# ELK RIDGE ESTATES

A SUBDIVISION OF A PORTION OF THE SOUTHEAST ONE-QUARTER  
OF SECTION 23, T 12 S, R 66 W OF THE 6th P.M.,  
EL PASO COUNTY, COLORADO

JOB NO.: 43116  
JUNE 29, 2026  
PAGE 2 OF 3

# ELK VIEW ESTATES

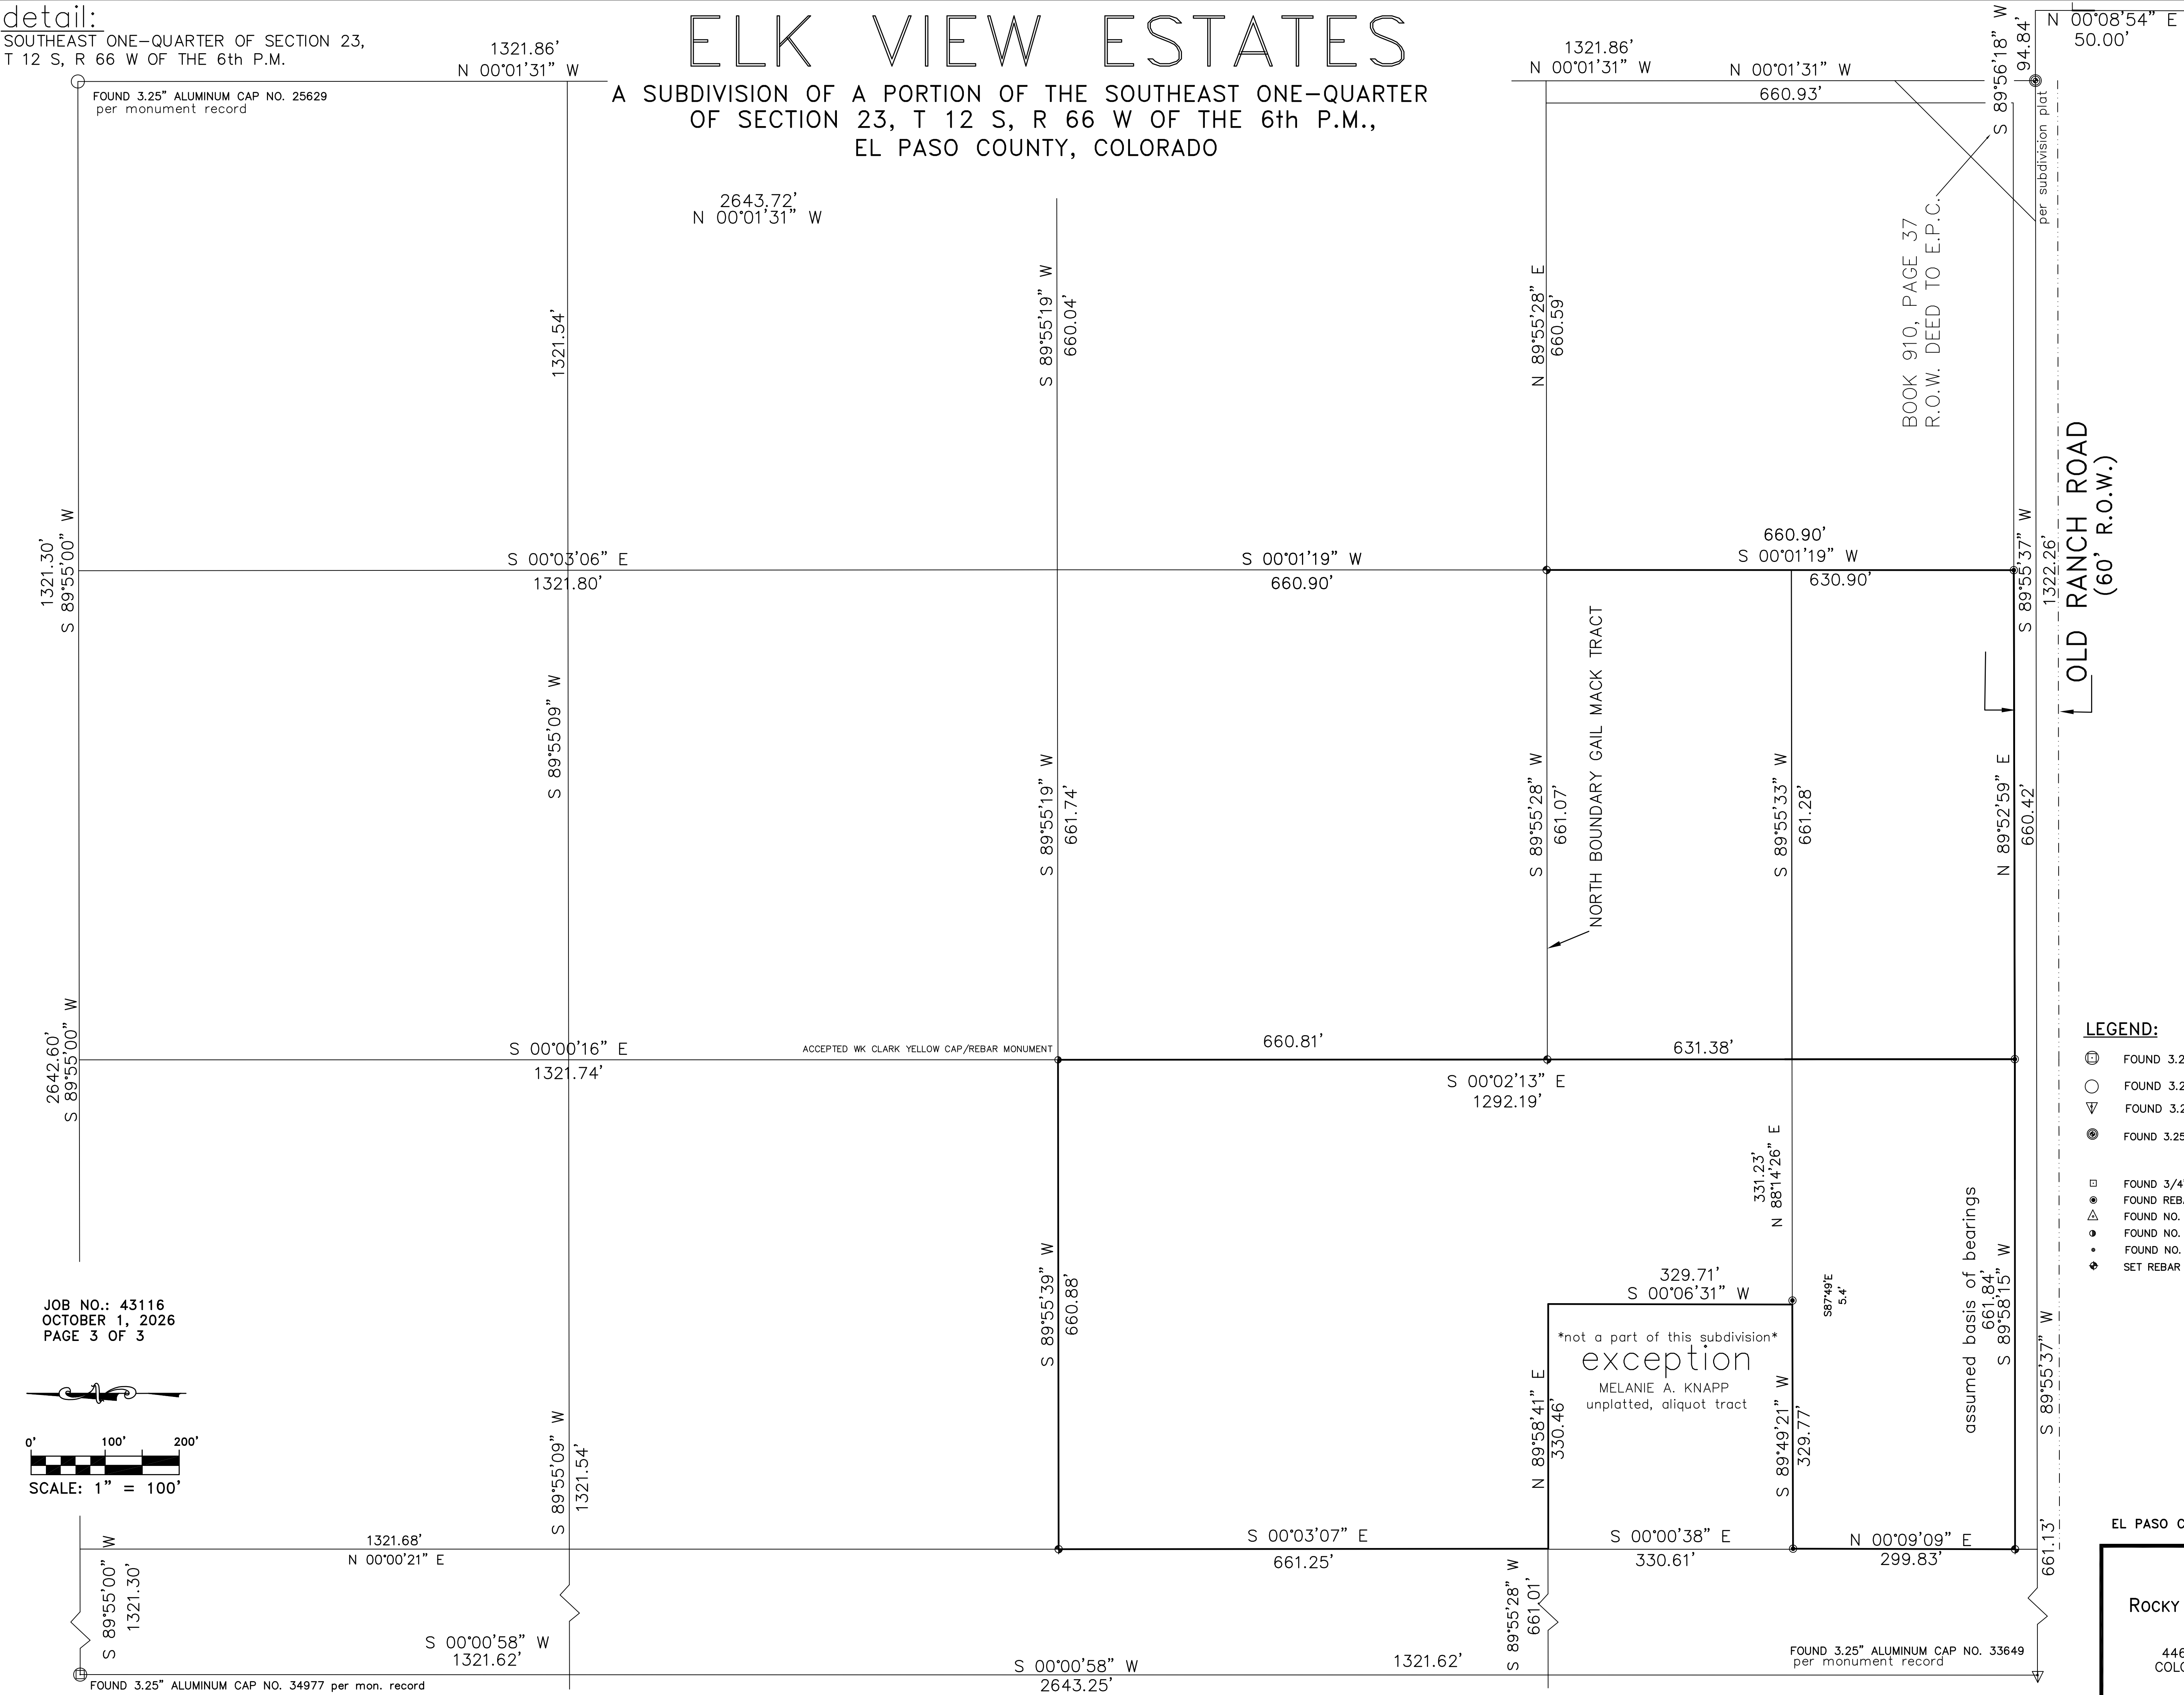
**UNRESOLVED:**  
These are not on the  
Title Commitment.  
Please provide copies  
of these documents  
for review.

Per other drawings, it  
appears existing gravel  
road extends out of  
easement. Easement  
should be  
extended/revised to  
encompass existing road.

correct the spelling of  
POINT
